TENDER DOCUMENTATION

ACCESS REVIEW - CONCERT HALL

This report is for the assessment of the Concert Hall portion of the Sydney Opera House Renewal Project to assess compliance with the provisions of the Disability Discrimination Act 1992, the Disability (Access to Premises – Buildings) Standard and the National Construction Code together with the relevant Australian Standards.

This report is based on the tender architectural documentation prepared by ARM Architects for the Concert Hall refurbishment works.

Status
DEVELOPMENT APPLICATION ISSUE
Contract
BDM-168
Dwn
RS
Date
21/02/2019
Ckd
AH
Scale
1:50 @ B1

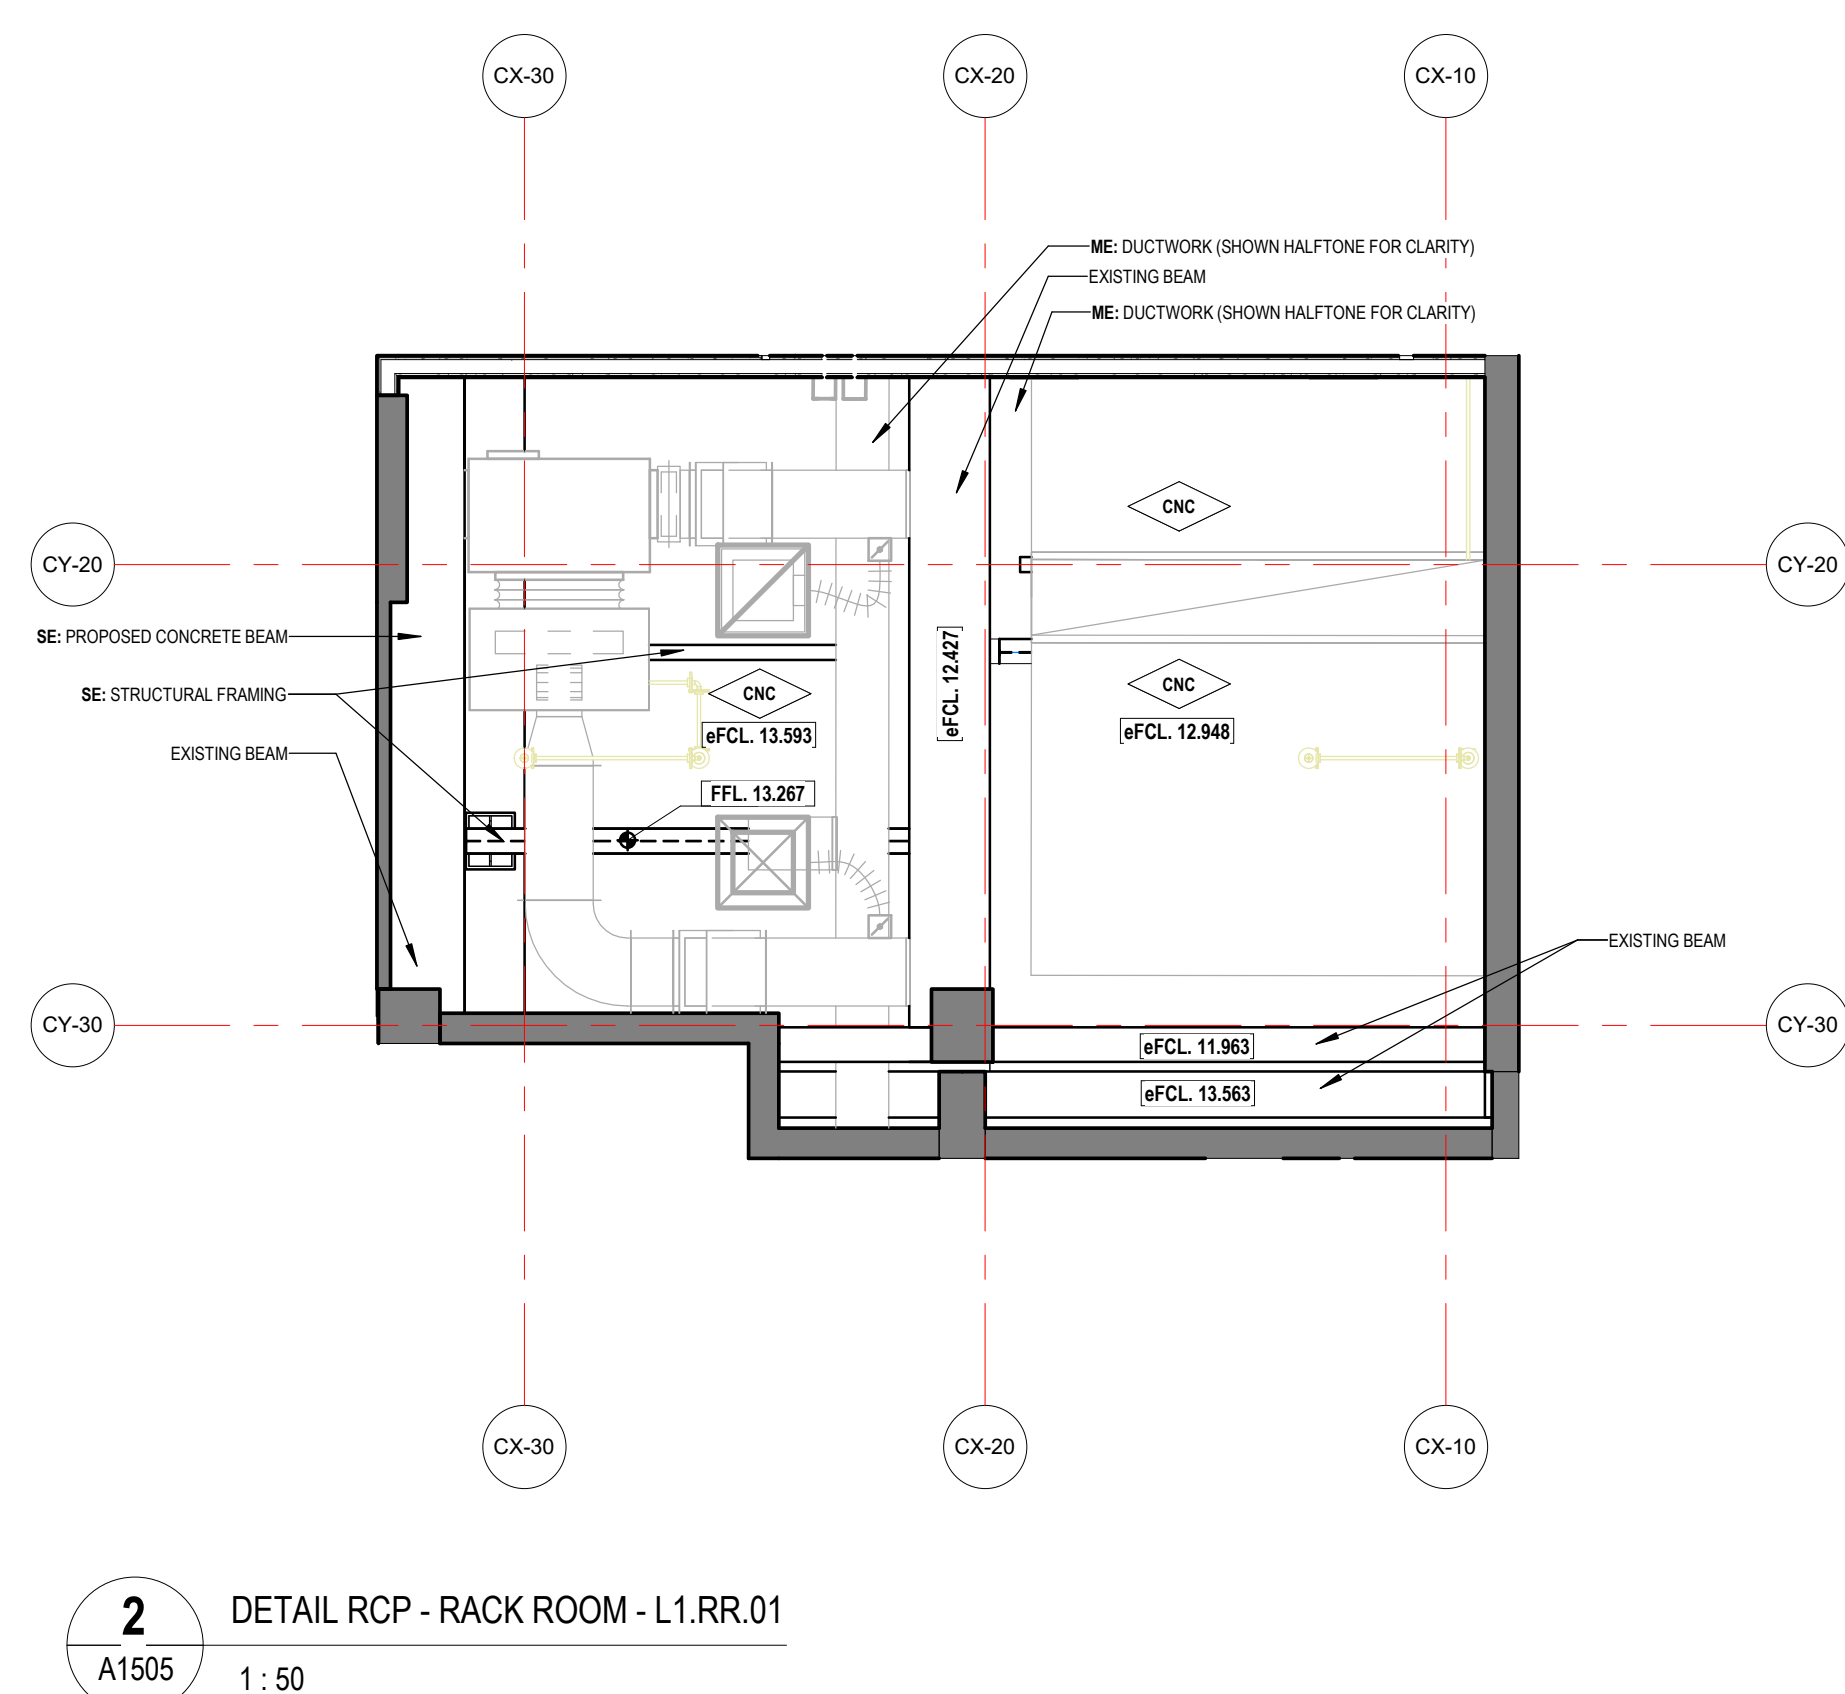
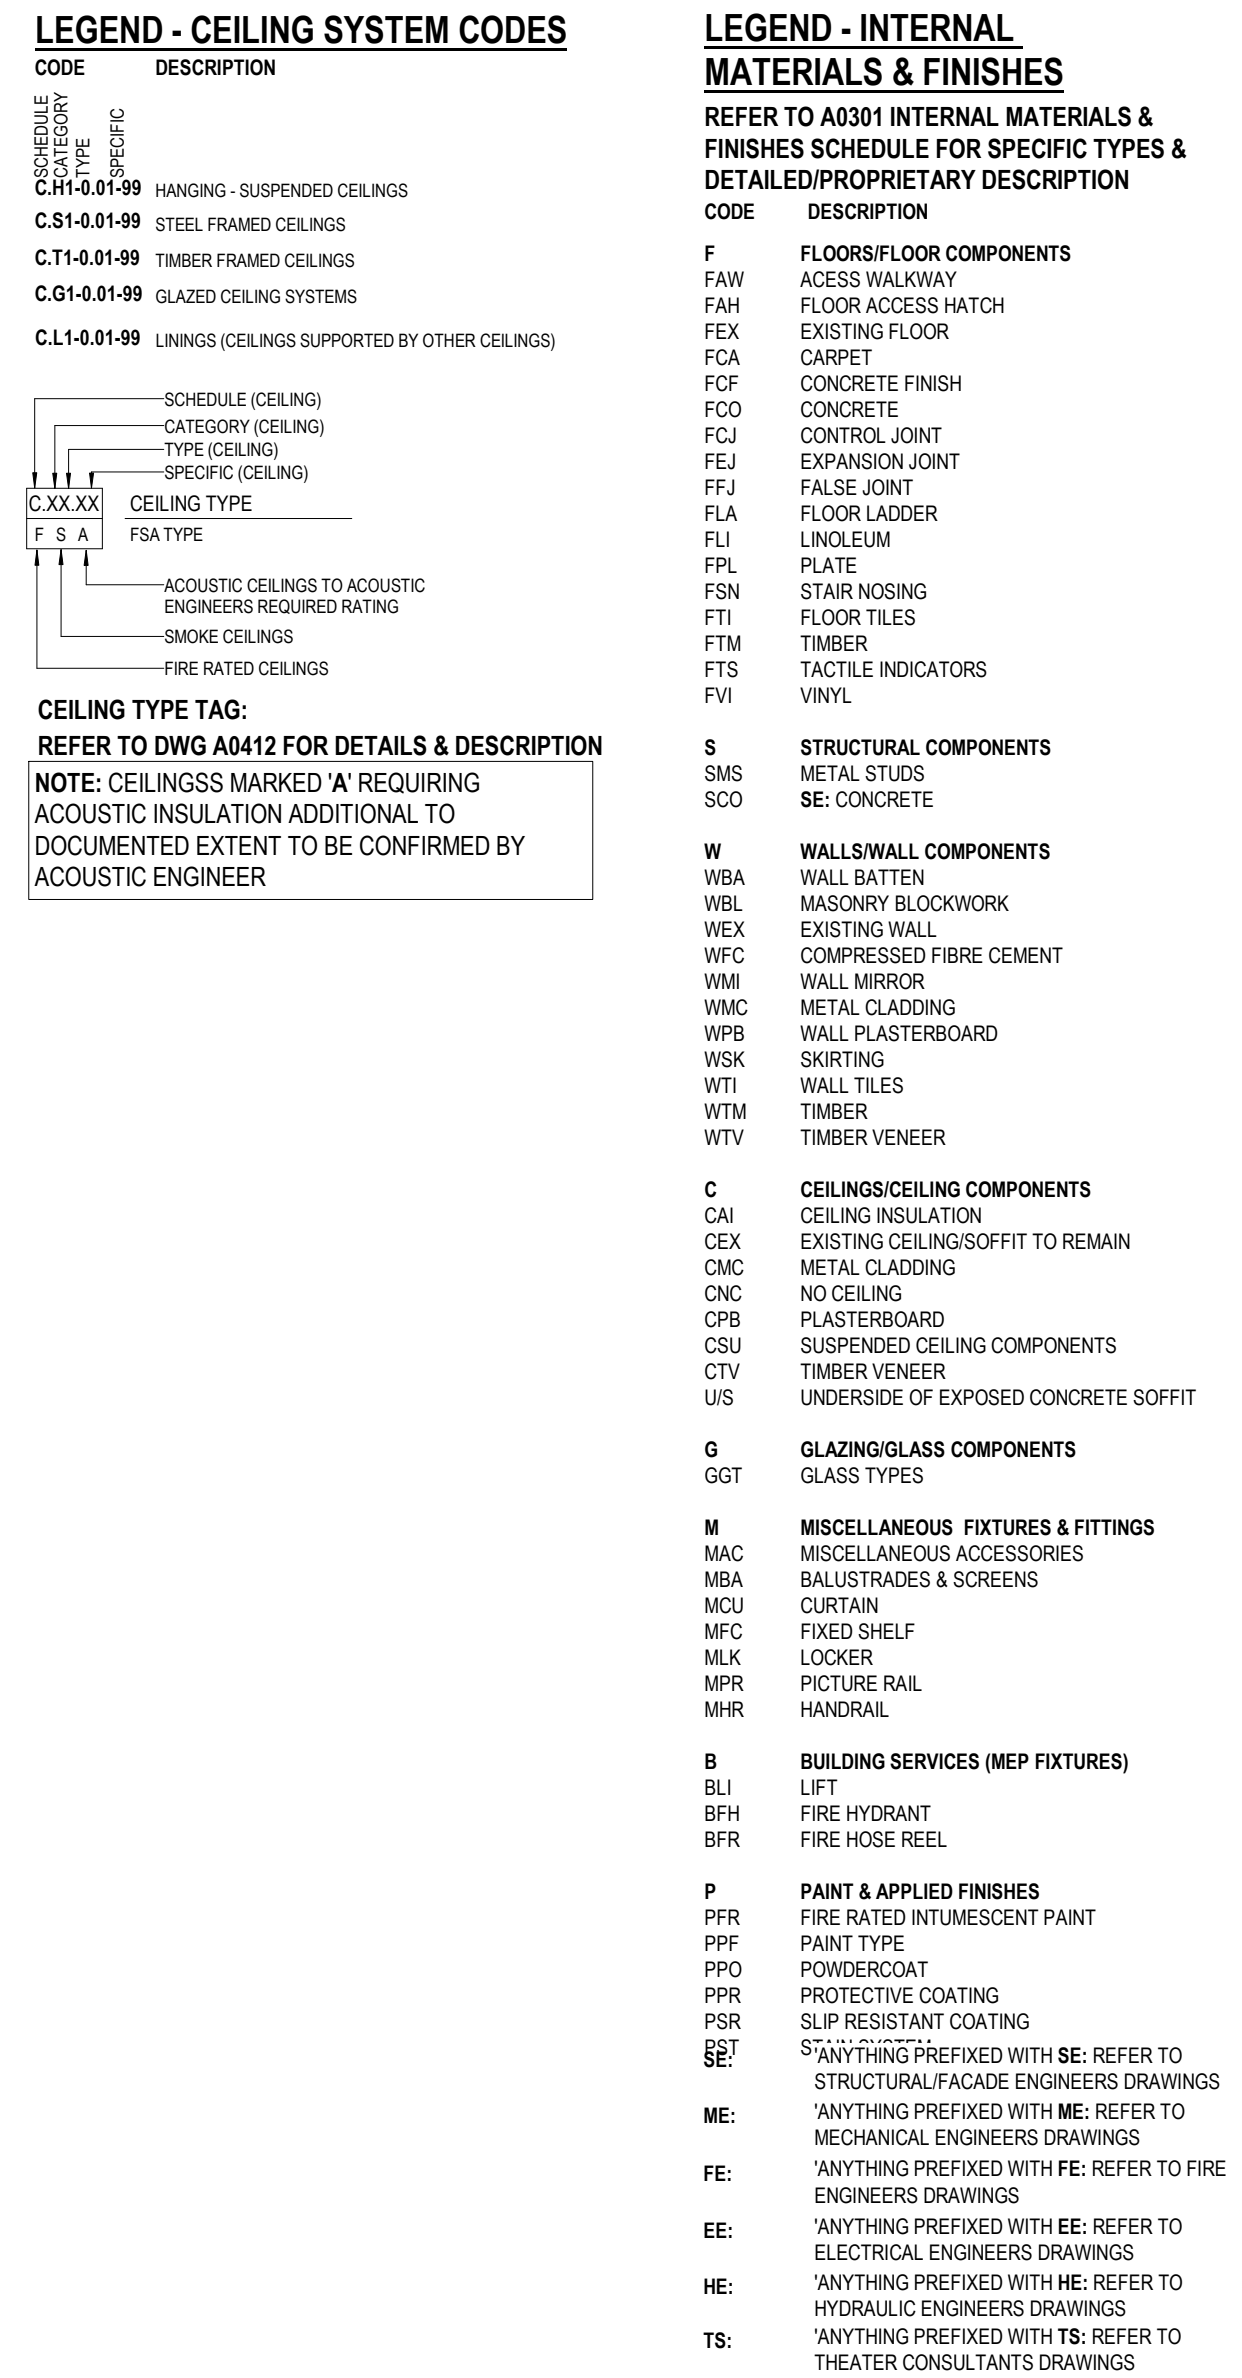
10.3 Ramps	Satisfied	The ramps accessing the Orchestra Assembly Room are addressed by way of a Performance Solution.
10.4 Curved walkways, ramps, and landings	Not Applicable
